## WEST SUSSEX COUNTY COUNCIL CONSULTATION

<b>TO:</b>	Arun District Council FAO: Harry Chalk
<b>FROM:</b>	WSCC – Highways Authority
<b>DATE:</b>	5 February 2025
<b>LOCATION:</b>	Sparks Yard 18 Tarrant Street, Arundel, BN18 9DJ
<b>SUBJECT:</b>	AB/6/25/PL Conversion of existing single residential unit with associated commercial space to form 3 No. residential units together with associated works and rear/side extension. This application affects the setting of listed building, affects the character and appearance of the Arundel Conservation Area, is in CIL Zone 2 and is CIL Liable as new flats.
<b>DATE OF SITE VISIT:</b>	n/a
<b>RECOMMENDATION:</b>	Advice

This proposal is for the conversion of existing single residential unit with associated commercial space to form 3 No. residential units together with associated works and rear/side extension. The site is located on Tarrant Street, a C-classified road subject to a speed restriction of 20 mph.

BLOCK PLAN

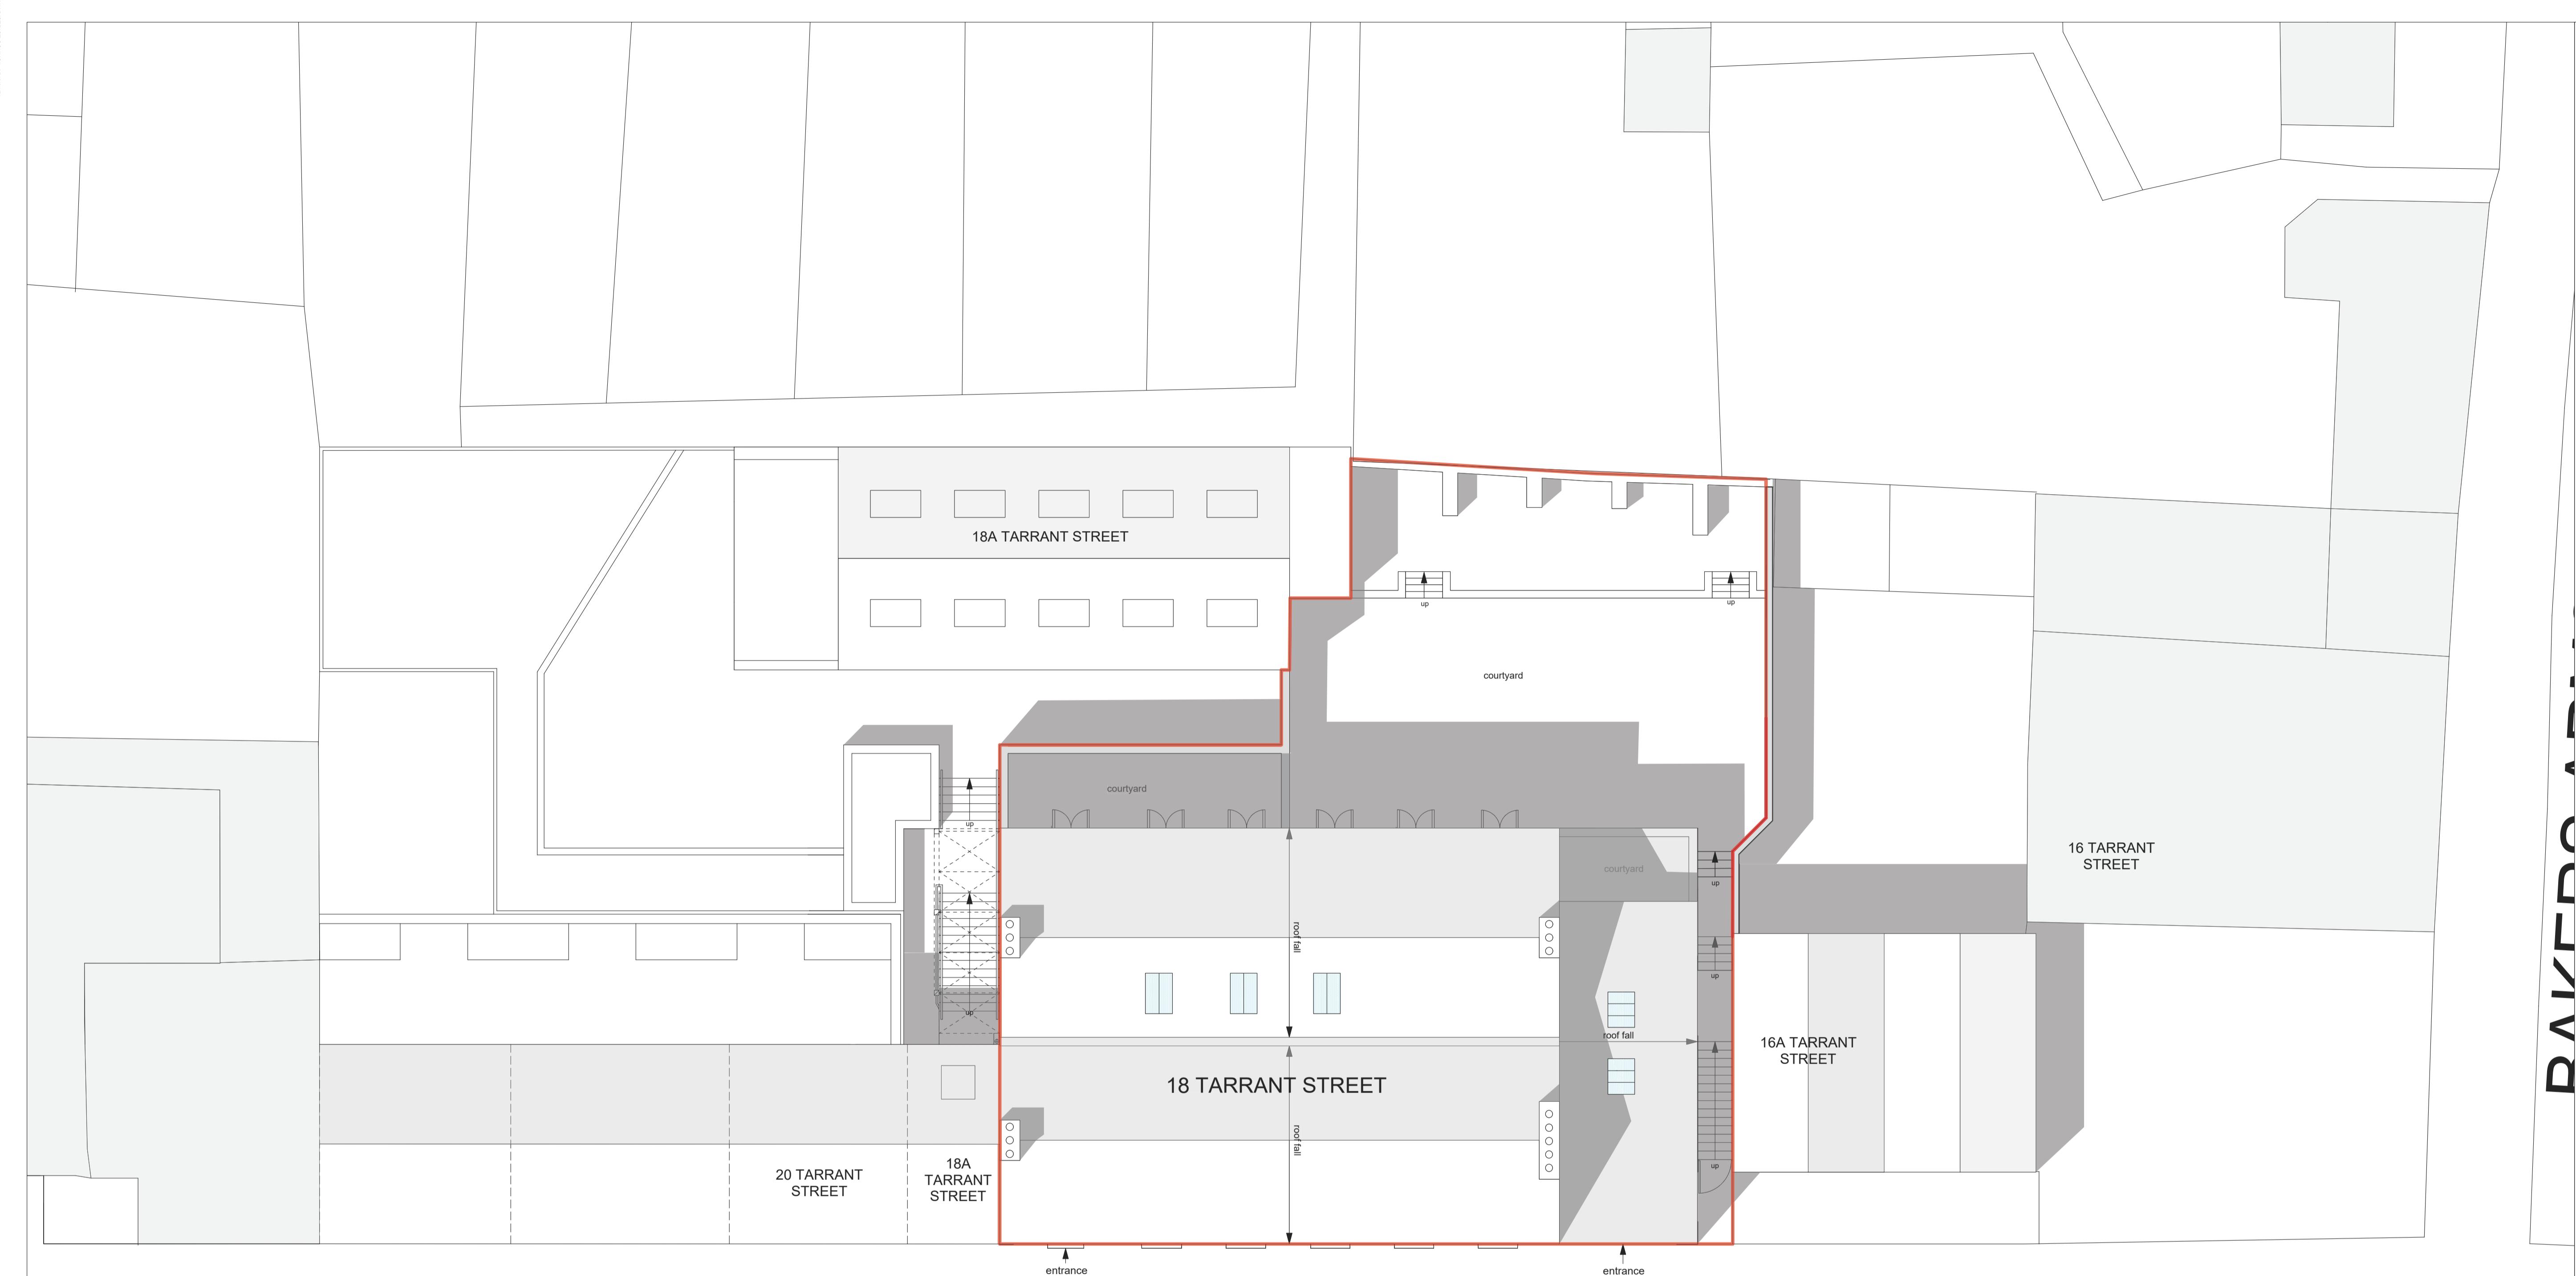
A nil car parking provision is proposed for the development. A development of this size in this location would require at least eight car parking spaces to meet Arun Parking Standards. Therefore, vehicular parking would have to be accommodated on-street.

No details regarding cycle parking provision have been provided. The LHA would request that secure cycle parking provision be provided for this development, if there is space within the site to do so.

No part of the development shall be first occupied until covered and secure cycle parking spaces have been provided in accordance with plans and details to be submitted to and approved by the Local Planning Authority.
